DRB Application No.: 04DRB-00775  
Project Name: NETHERWOOD PARK  
Agent: Southwest Surveys LTD

**DRB CASE NO/PROJECT NO: 1003183**

D.R.B. CASE NO.: 1003183

**RE: Lot 44-A, Block 19, Netherwood Park/minor plat**

PLAT OF
LOTS 44-A-1, 44-A-2, 44-A-3 & 44-A-4, BLOCK 19
NETHERWOOD PARK ADDITION
SITUATE WITHIN SECTION 10,
T. 10 N., R. 3 E., N.M.P.M.,
CITY OF ALBUQUERQUE
BERNALILLO COUNTY, NEW MEXICO
MAY 2004

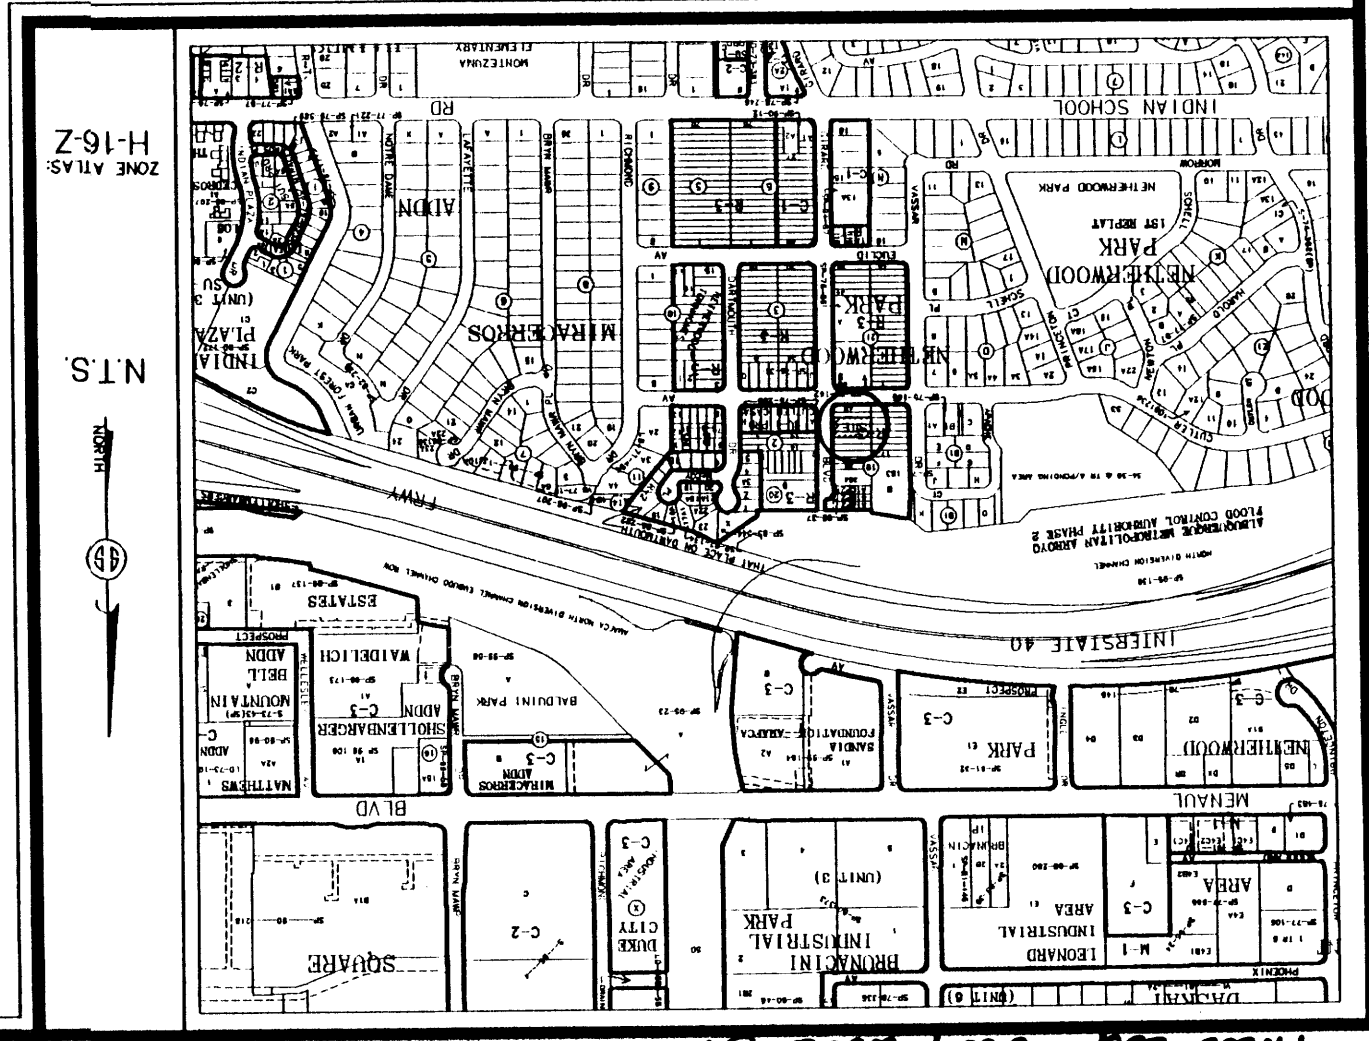
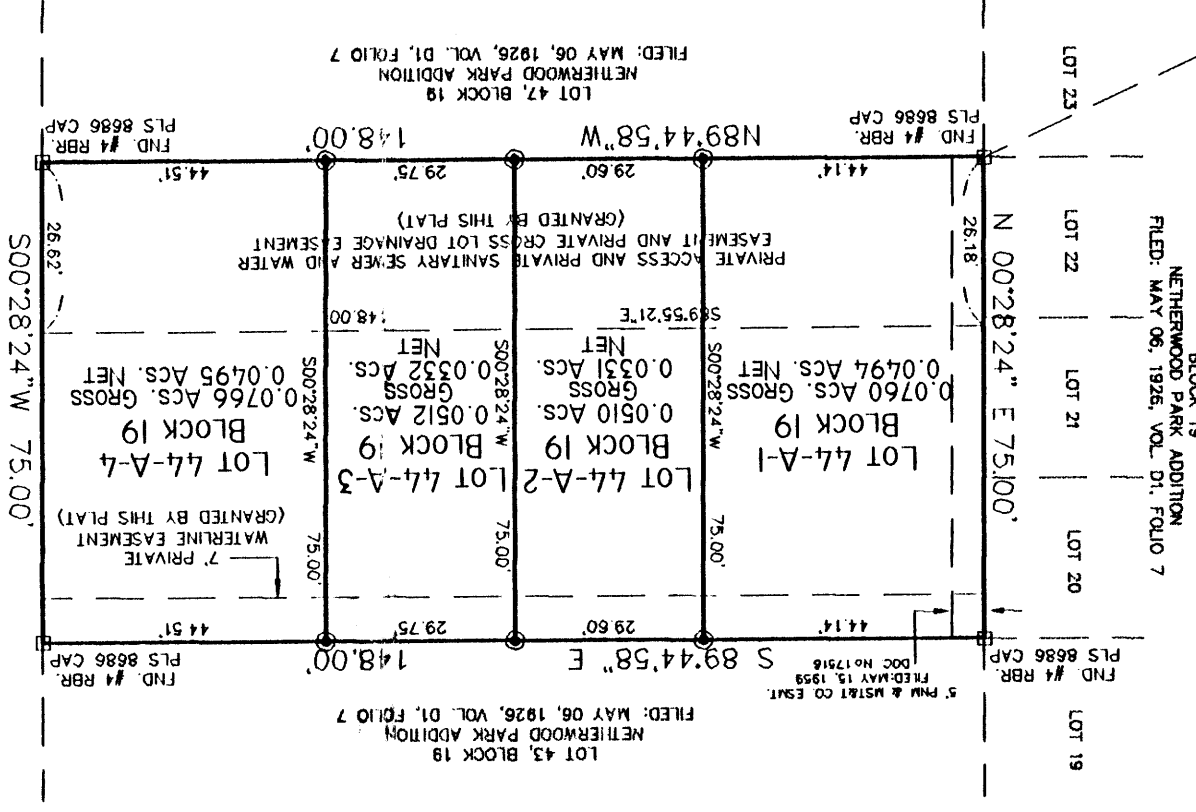
1. Need a Utility Plan showing proposed services for water and sewer.
2. No existing water/sewer accounts.
3. Condo subdivision appears the most feasible alternative.

AGIS dxf is <sup>not</sup> approved.

Are the units existing?
